RE: Response to Request for Information for South Eveleigh Locomotive Workshops (SSD-8517)

Ethos Urban has prepared this letter on behalf of Mirvac in response to the Department of Planning, Industry and Environment's (the Department) request for information (RFI) letter dated 12 May 2021 and the associated agency submissions received from the NSW Heritage Division and City of Sydney Council following the exhibition of MOD 9 for SSD-8517. This modification relates to the installation of three extraction hoods, fans and flues for three of the existing heritage coke furnaces in the Blacksmith workshop (Bays 1 and 2) of the Locomotive Workshops, South Eveleigh.

This RFI response letter addresses the items raised by the Department in the RFI letter and the agency comments. The response is accompanied by an updated East Elevation Plan at **Attachment A**.

2 PROPOSED - EAST ELEVATION - RETAIL
1 : 250

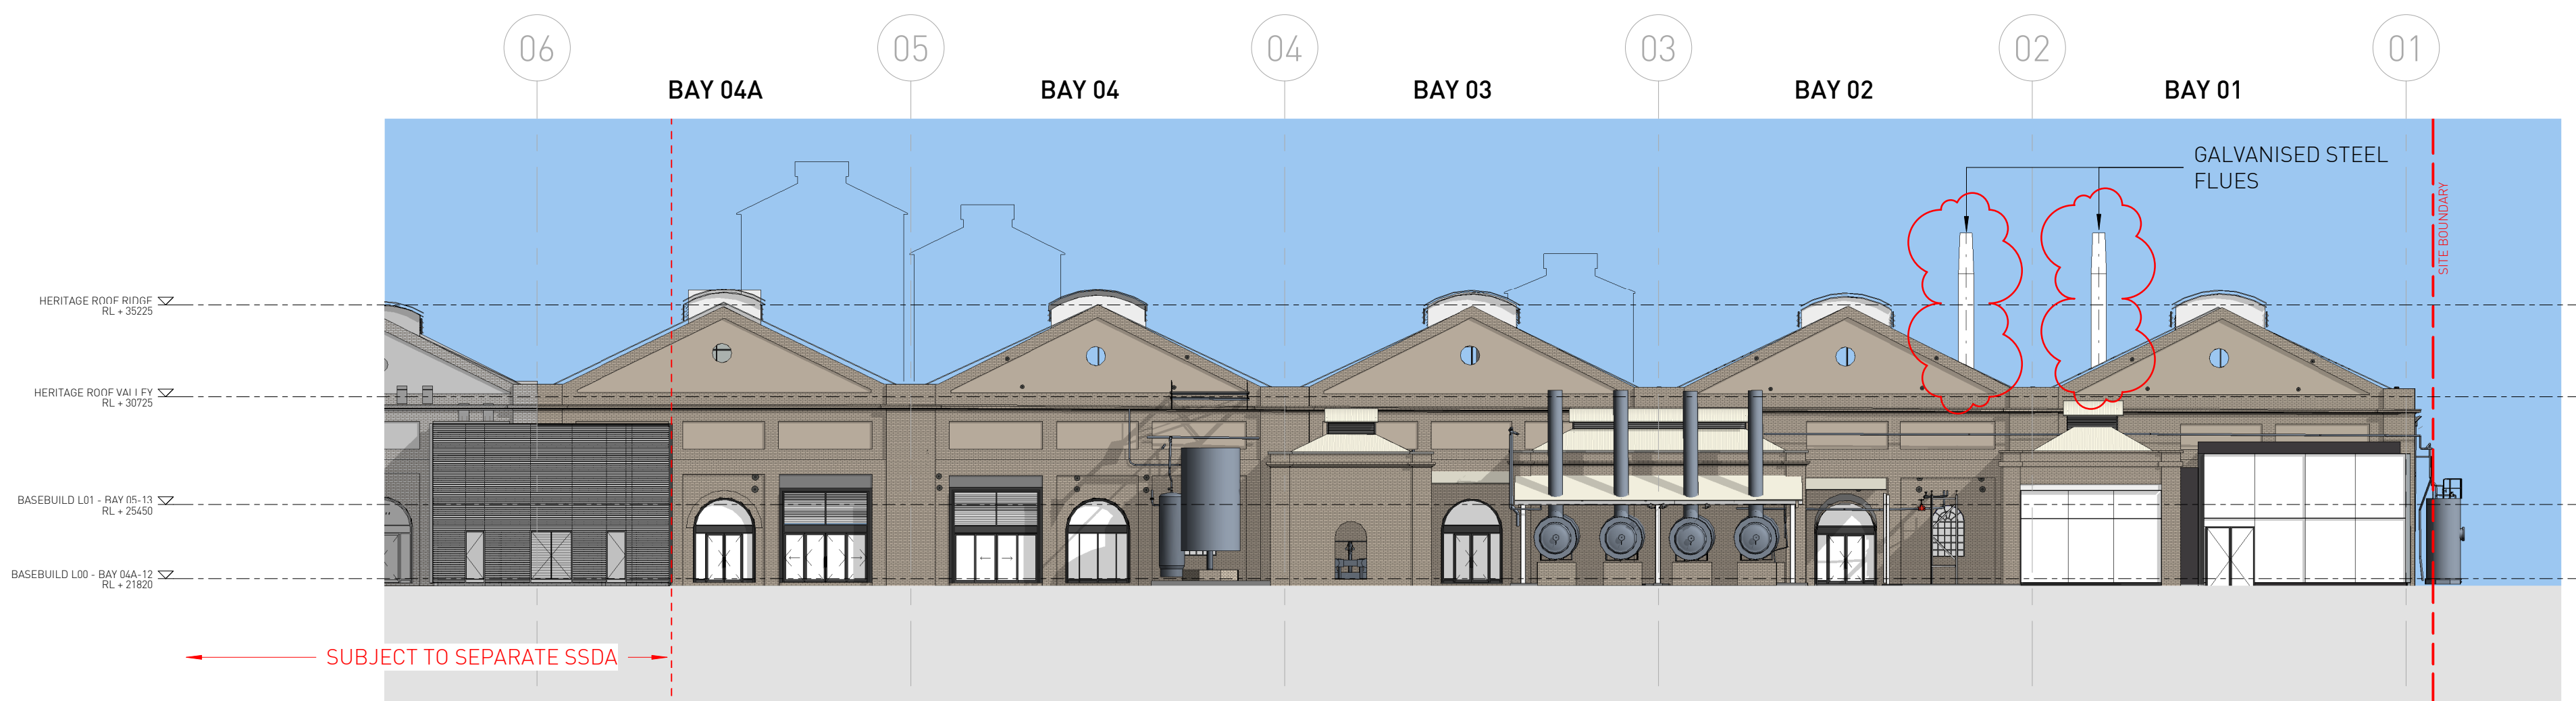
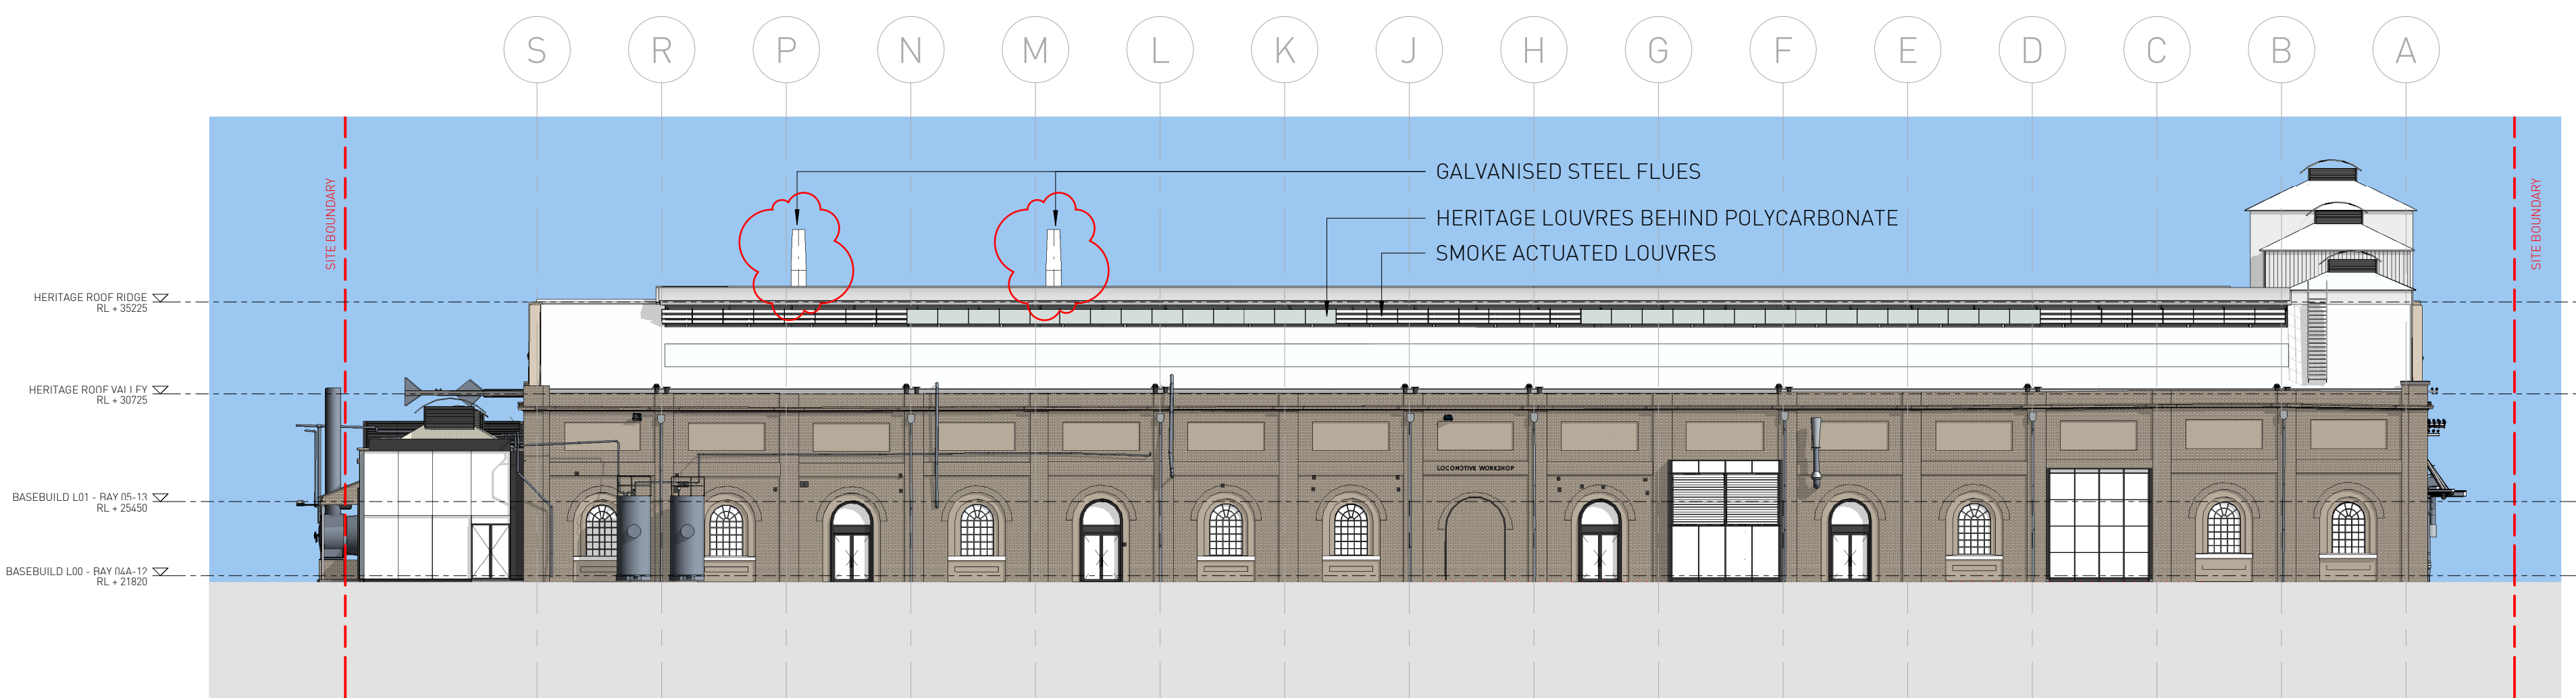
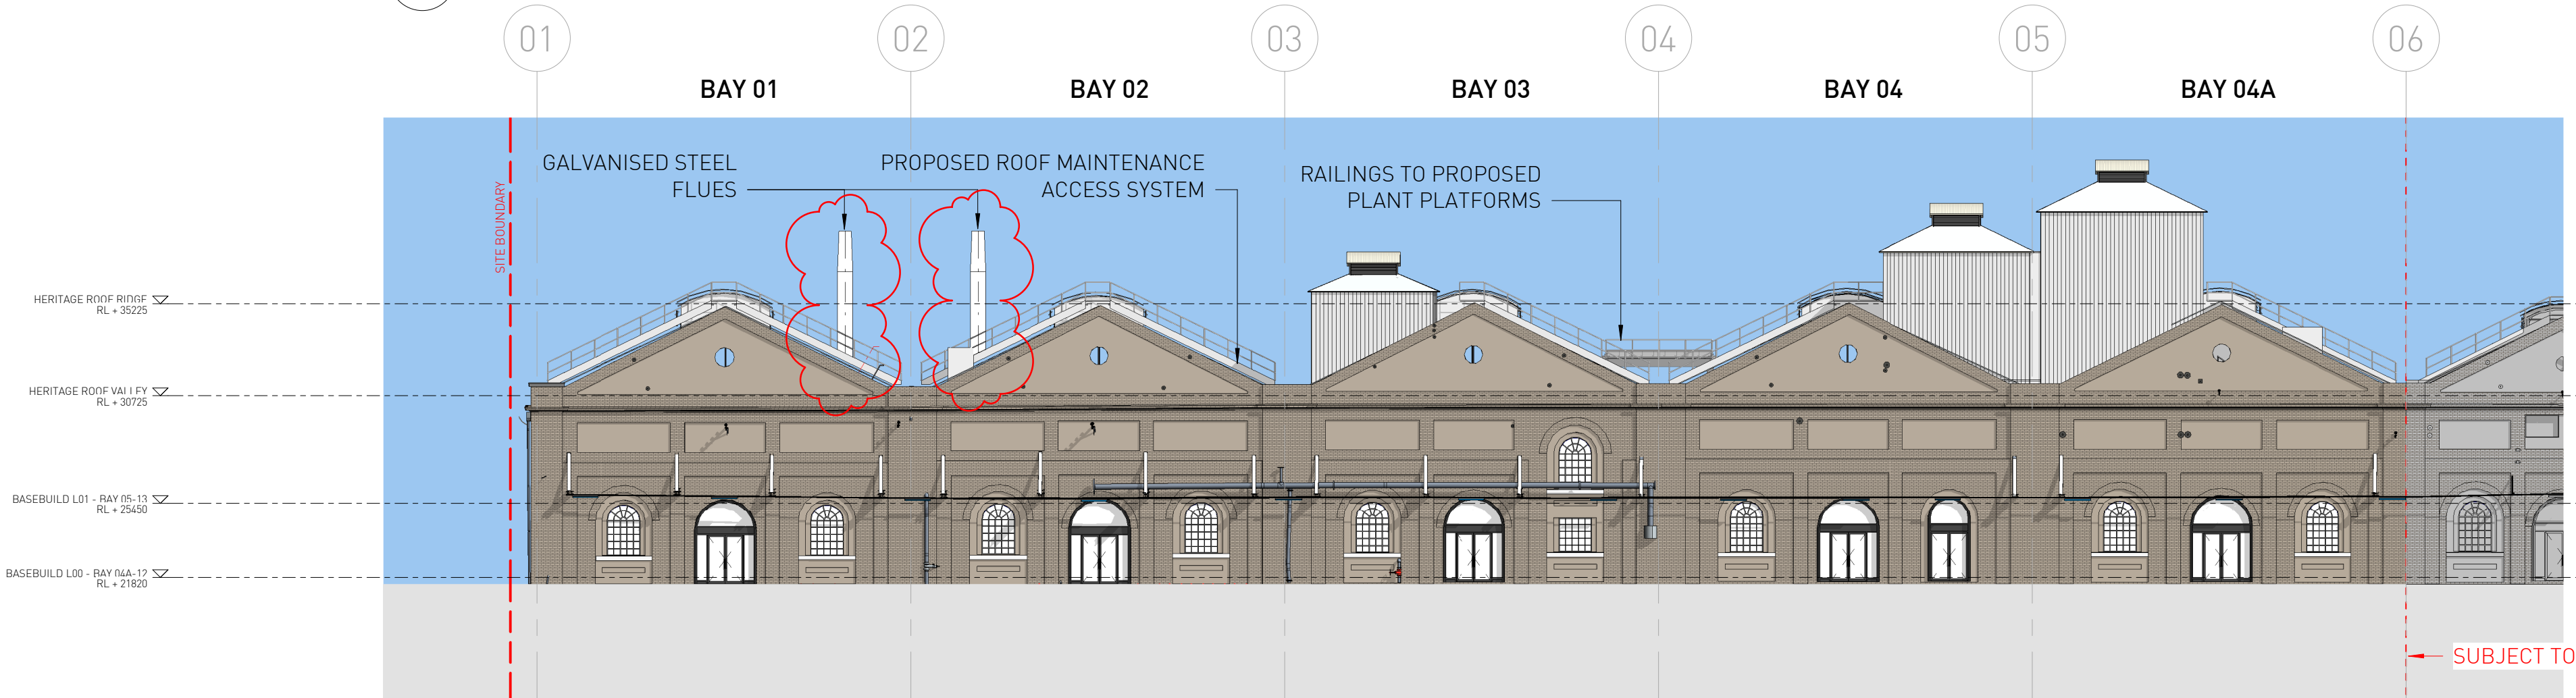
Comment	Response
Department of Planning, Industry and Environment	
The Department requests you provide an updated elevation drawing SA-AR-DWG-BB-B4-0340 to show the proposed flues from the eastern elevation of Bays 1-4a.	This is provided at Attachment A .
City of Sydney	
The City of Sydney raises no objections to the proposal.	Noted.
From a heritage perspective the proposed flues have galvanised steel finish and appear to be supported from the existing trusses by cables. This is all considered reversible and can be supported as they fit in with the industrial context of the site.	Noted.
In regard to the air quality impacts, however, the following items require further review by the Department of Planning, Industry and Environment (DPIE): The Mechanical Ventilation design which is claimed to be more efficient at capturing direct exhaust emissions and smoke generated during furnace and oil quenching operations, to ensure future staff are protected. All mechanical ventilation should be compliant with AS1668 and signed off by a competent person (e.g. mechanical engineer or similar) prior to the issue of a Construction Certificate.	Noted. This is supported as an appropriate condition of consent.
